From: Justin Turnbull <justin.turnbull@co.kittitas.wa.us>
Date: 10/31/16 4:31 PM (GMT-08:00)
To: Lucas Huck <lucas.huck@co.kittitas.wa.us>
Subject: RE: BL-16-00016 Potucek (Disregard previous email, date incorrect)

Subject: BL-16-00016 Potucek

Existing Plat

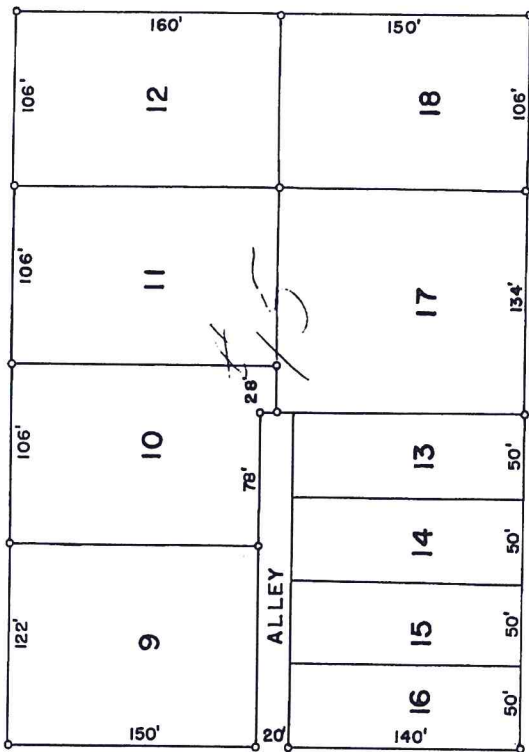
I have no concerns regarding this EXCEPT for verifying that the parcels reflected on the Plat of record are indeed correct, and were not previously combined, as there appears to be a discrepancy between the Platted lines and the Tax parcels per our GIS. In reading through the review, it sounds like Doc was already looking into this.
